21 October 2020

**EPA Advice on Environmental Impact Statement (PAE-9433811)
State Significant Development 10396**

Thank you for the request for advice from the Department of Planning, Industry and Environment (DPIE) requesting the review by the Environment Protection Authority (EPA) of the Environmental Impact Statement (EIS) for the proposed Kings Park Metal Recovery and Recycling Facility Expansion (SSD 10396) at 23-43 and 45 Tattersall Road, Kings Park, NSW (Premises).

Figure 3 Process flow diagram

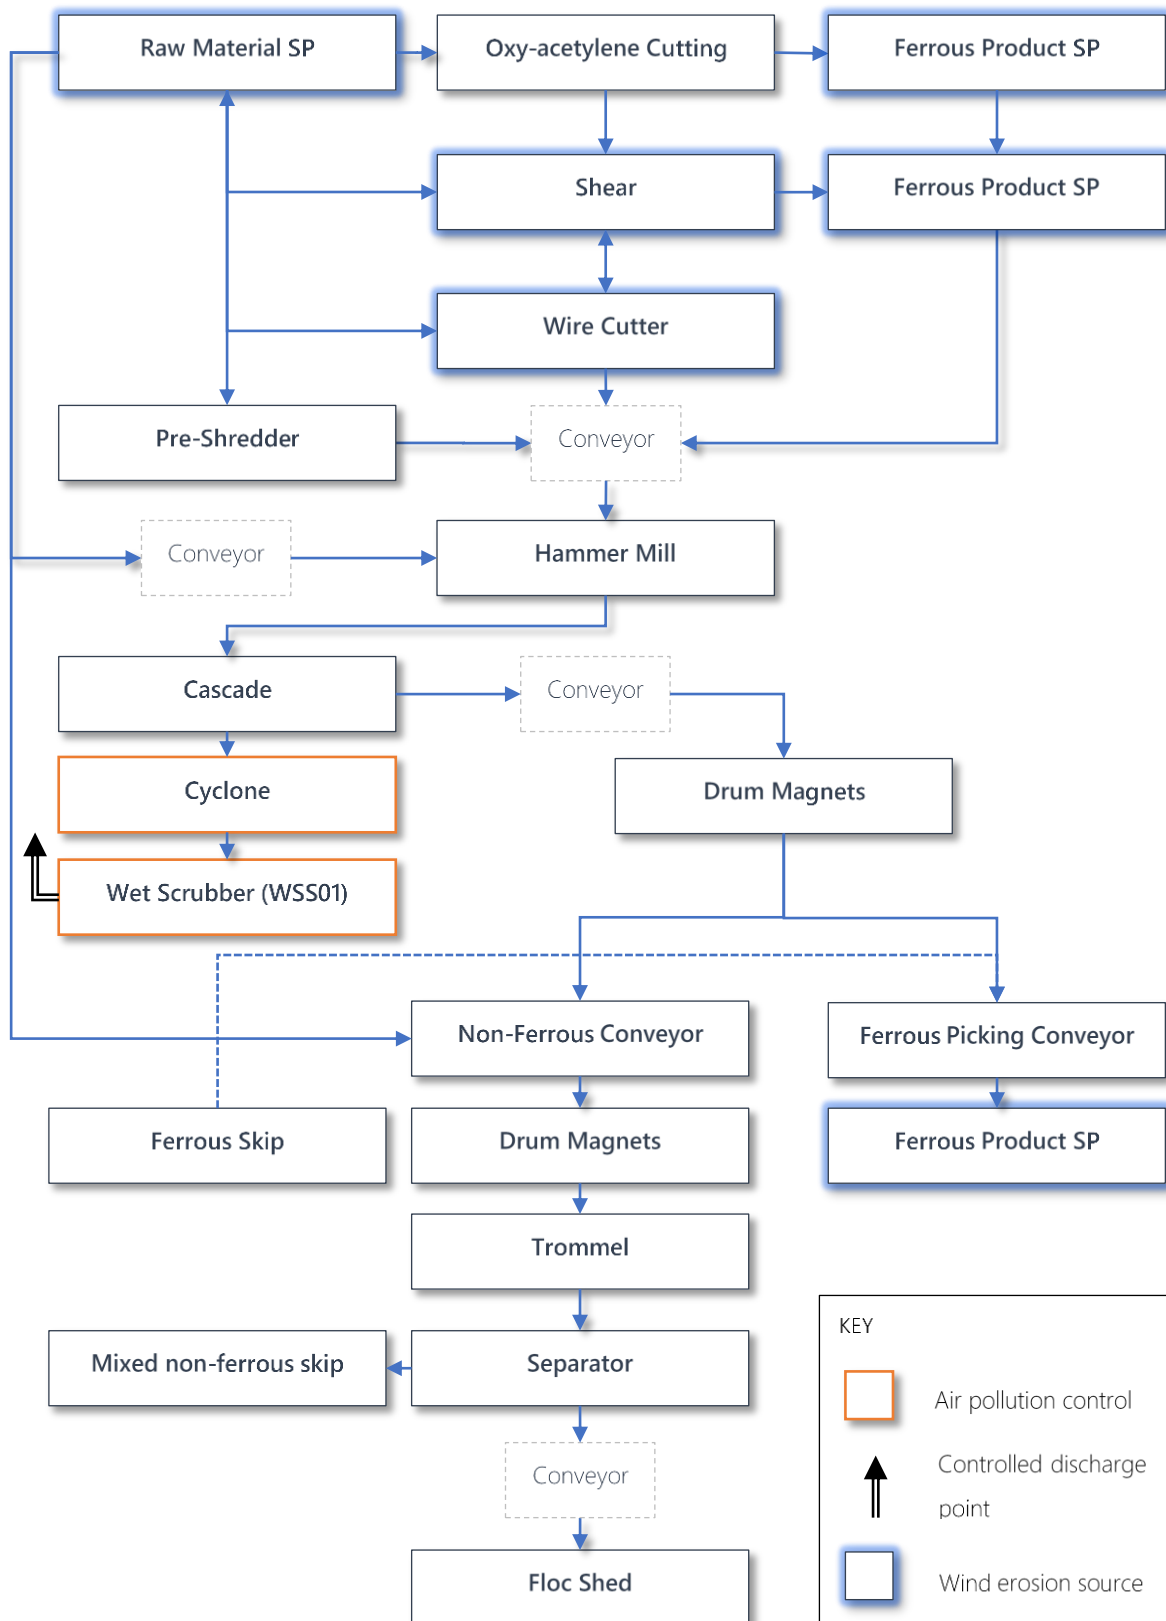
The proponent must provide a clear linkage between emission sources (Table 14), process (Figure 3), movement of materials onsite, throughput and activity rates.
